Subject: Planning Consultation on: LU/173/26/OUT

Response to Planning Application

Application ref: LU/173/26/OUT

Location: Westholme Nursery Toddington Lane Littlehampton BN17 7PP

drawing Block & site location plan

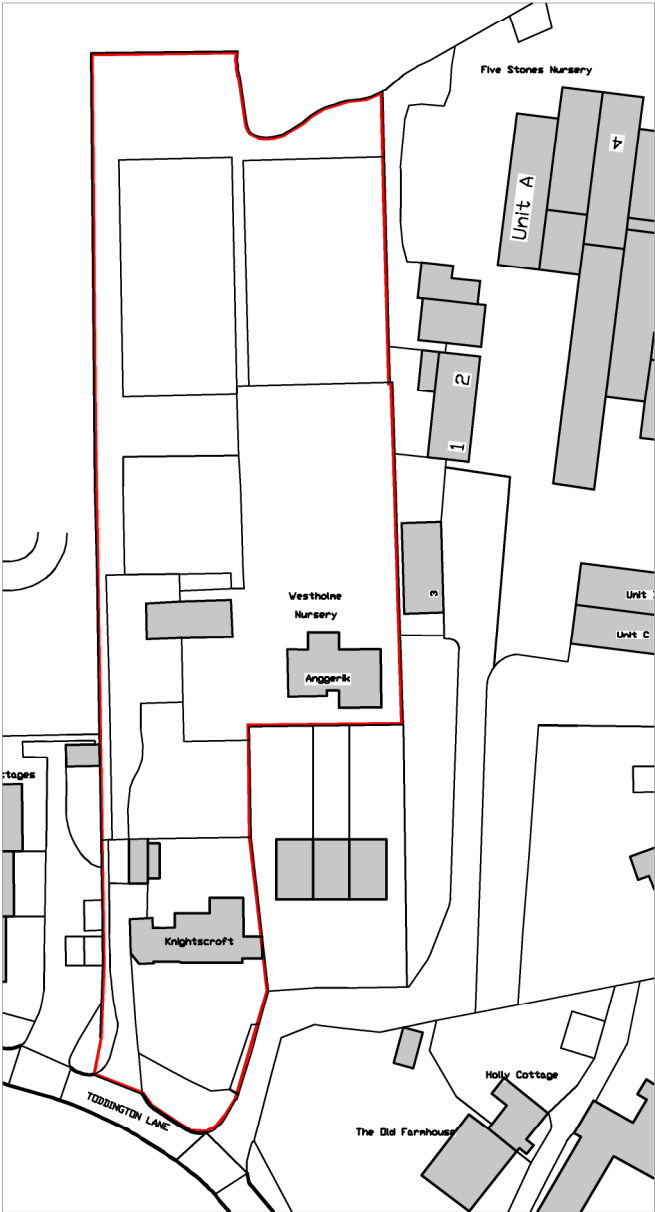
The application states that matters of scale, layout, landscaping and appearance would be reserved for subsequent determination. The Proposed Site Plan (Drawing No. TA 1626/02 Rev B details how the proposed 20 units, access road, car parking space, amenity space and landscaping may be delivered on the site. It should be noted that the landscape detail has been suggested to be determined under reserved matters however clarification should be sought at this stage re the layout shown and how this conforms to meet SPD requirements for POS provision as outlined in our ADC SPD Open Space, Playing Pitches, Indoor and Built Sports Facilities January 2020.

A development of this size 20no dwellings would require the provision of onsite POS minimum area of 1,650m² (1,408m² POS and 242m² Play) **It is unclear** from the Proposed Site plan or the DAS **where** the POS and **LAP provision are to be located**. There is a large area shown in green to the rear of the proposals within the floodzone area however this is not detailed for use and confirmation should be sought if this is to house the POS and play requirements triggered from this development? **Confirmation of quantum and location sought re POS and location of the provision of onsite, unequipped natural play LAP area.** LAP to include such features as landform, boulders or logs, seat and litter bin. POS provision needs to be usable areas of land not formed from left over narrow strips or verge areas.

The proposals as shown have not incorporated play in the form of LAP provision which would be a requirement of the development.

The layout would need to further detail the SuDS provision within the development. SuDS are required to be fitting with the development and well designed to be an asset to the site, to provide interest, visually and biodiversity enhancement.

A full and detailed landscape scheme will be required to be submitted for approval, detailing species choice, quantities, planting densities and size at time of planting. This should be plotted in plan and list form and in relation to the trees and vegetation to be retained so that a clear picture of the proposals can be seen. These details are required to ensure that appropriate screening is provided, maintaining and uncompromising the setting and ensuring that the proposals fit within the area of neighbouring properties, providing screening as required, increasing biodiversity and wildlife habitat.

Recommend confirmation sought re location and quantum of Public Open Space (POS) provision and location and inclusion of LAP provision proposed for this development.
Recommend further landscape detail will need to be submitted at reserved matters stage.
